Planning Inspectorate's Reference: EN010148

**Subject: Application for an Order Granting Development Consent for the
Tween Bridge Solar Farm**

DEADLINE 3 SUBMISSION

30 June 2026

Figure 6.6: Screened Zone of Theoretical Visibility with Landscape Character Areas and Viewpoints

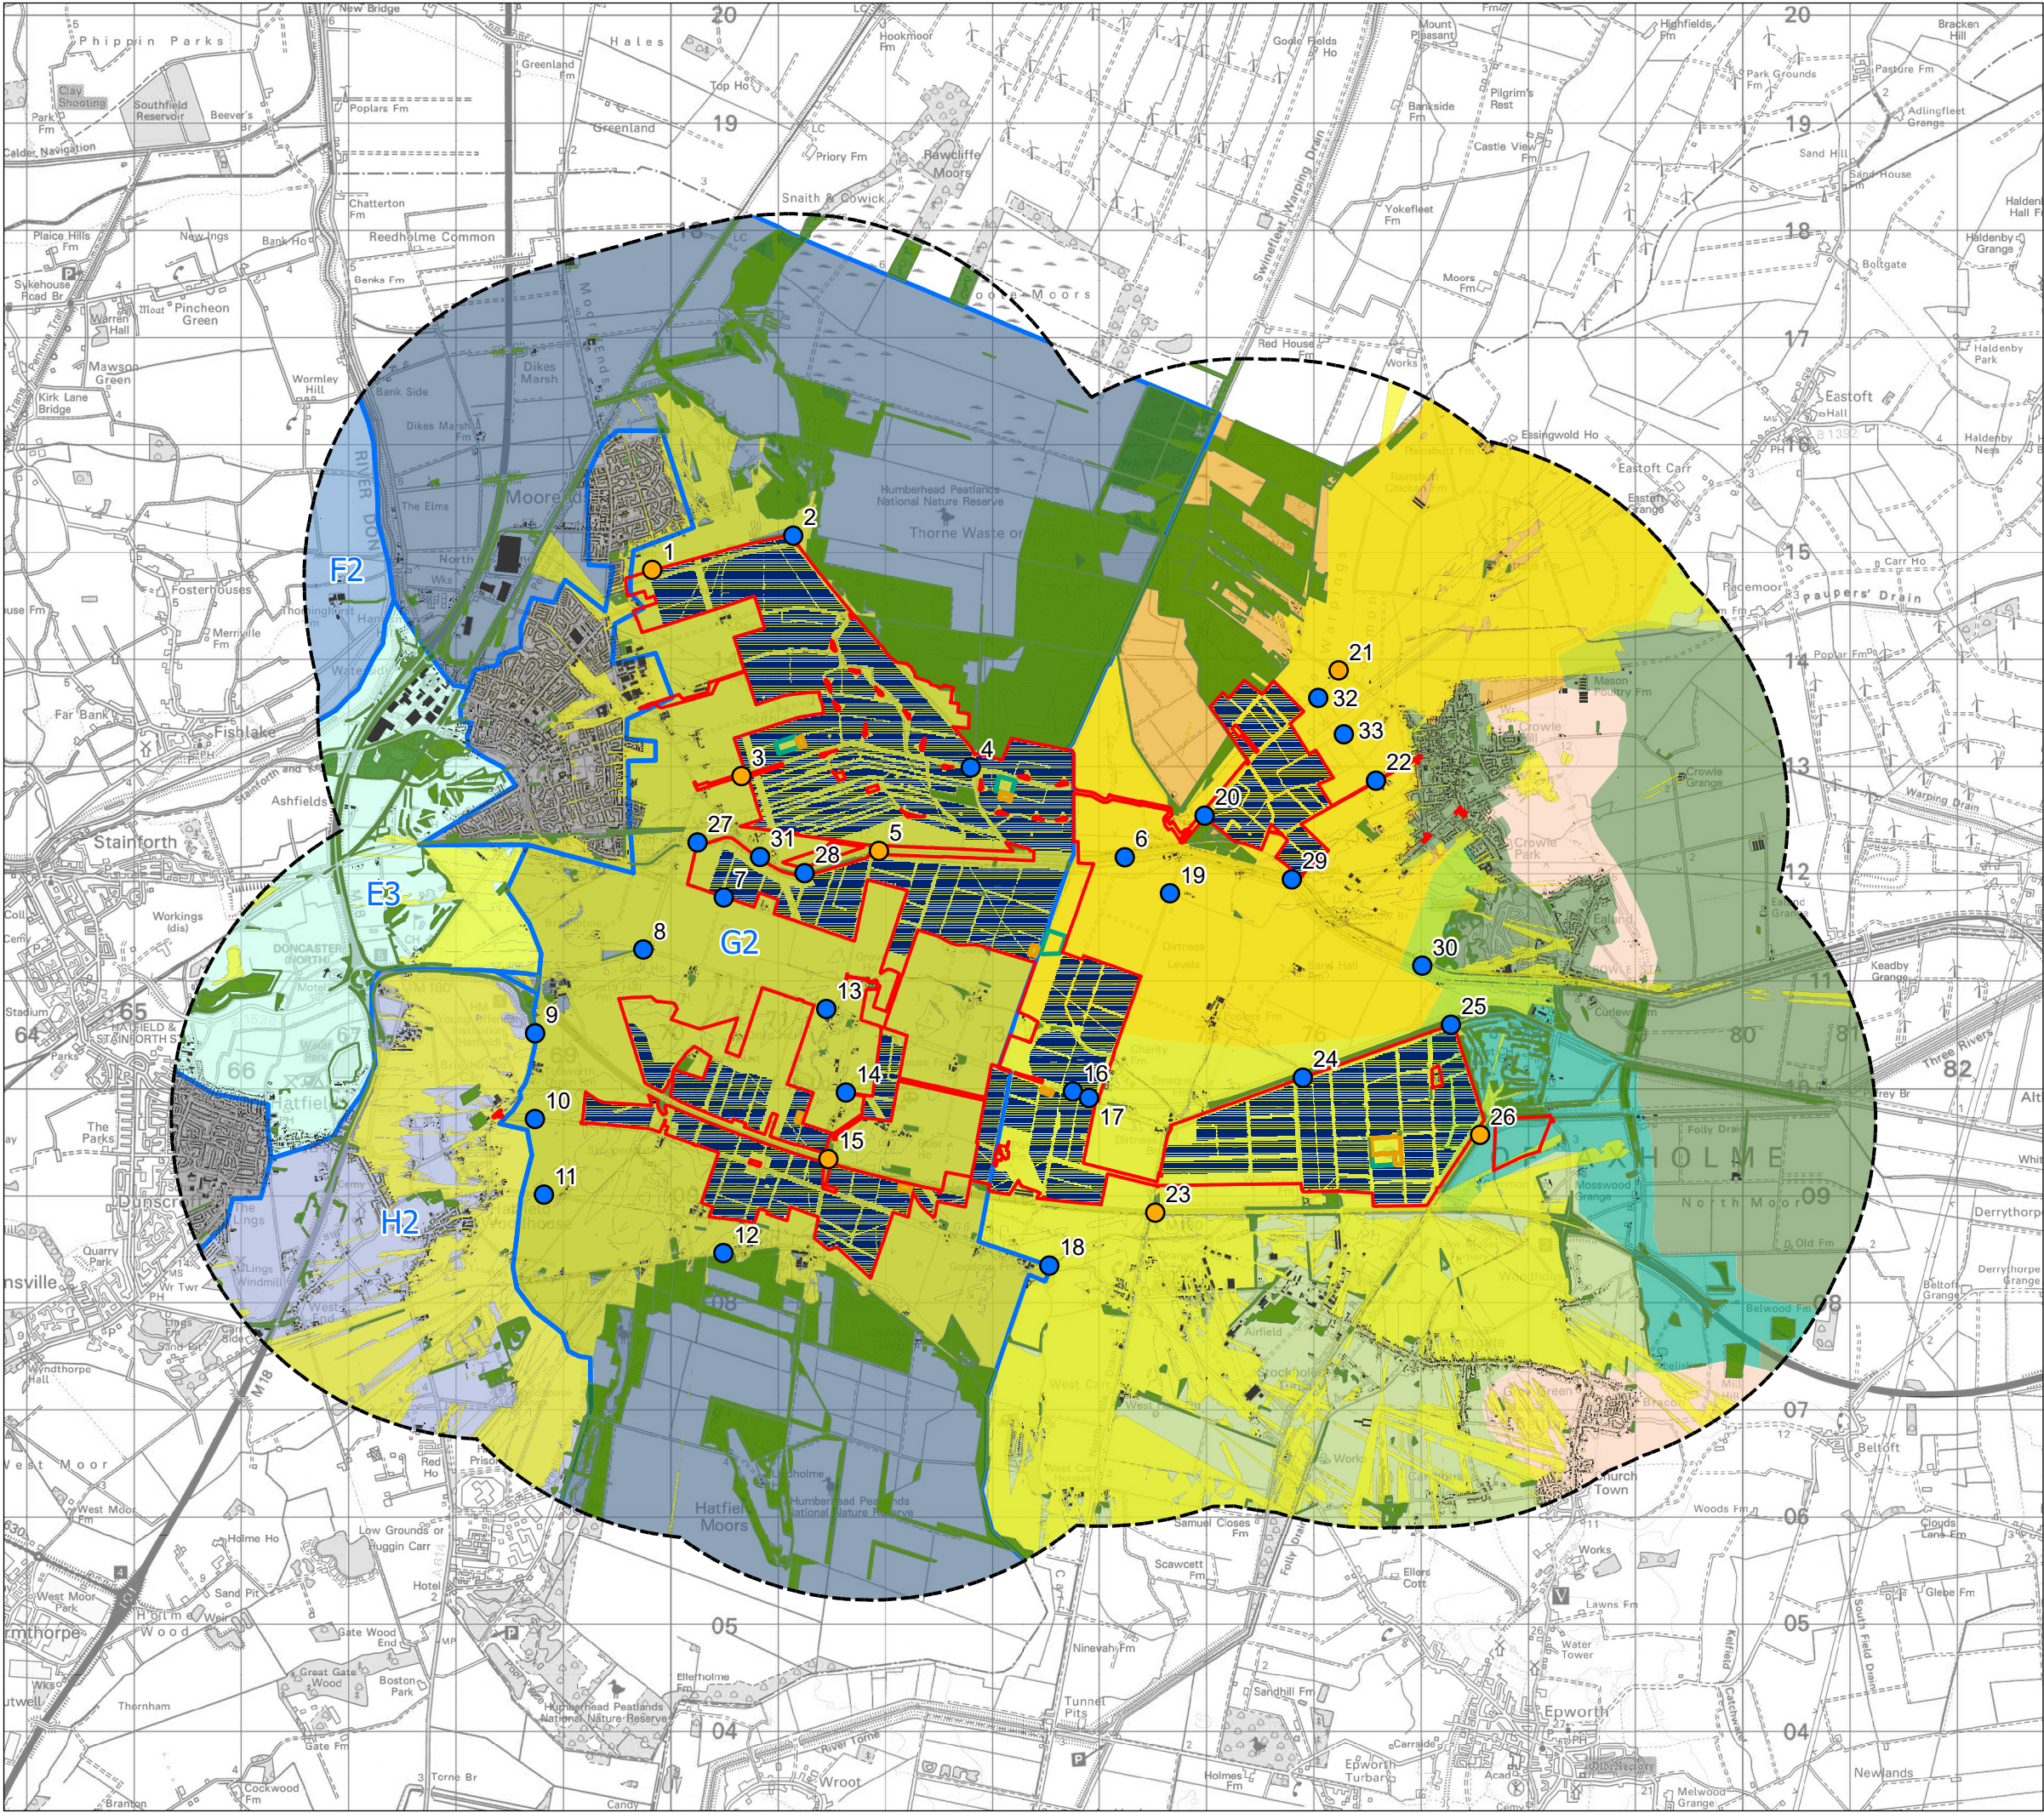
- 3.5 NLC agrees that there is limited assessment of how the landscape character would be affected by the development in the LVIA. A number of factors should be taken into consideration when predicting and determining landscape effects. As described in GLVIA3 these included 'change in and/or partial loss of elements, features or aesthetic or perceptual aspects that contribute to the character and distinctiveness of the landscape; addition of new features that will influence the character and distinctiveness of the landscape, the combined effect of these changes on overall character'. These should all be described as fully as possible.

- 3.6 The description of the magnitude should have reference to size or scale relating to the extent that existing elements that will be lost and the degree to which the landscape will be altered. This is different to the proportion of the LCA affected. Geographical extent is also an important consideration, but this relates to whether the proposals influence the site at various scales – such as site level, immediate setting, character area or larger scale.

- 3.7 The LVIA does not detail the size or scale of the change and it does not address the landscape character at the various geographical extents for each parcel. For a site of this size NLC would have expected the assessment to address the effect on landscape character with consideration given to the various parcels of land, rather than a generic assessment of the whole site. It does not contain sufficient detail to determine the outcomes assessed.

- 3.8 In addition, it is noted that the applicant states in their response that 'Each of the local character areas are relatively large scale and extend beyond the extents of the study area'. The acknowledgement of the large scale of these landscape character areas suggests that smaller areas should be considered within the assessment to understand the effects at a local scale.
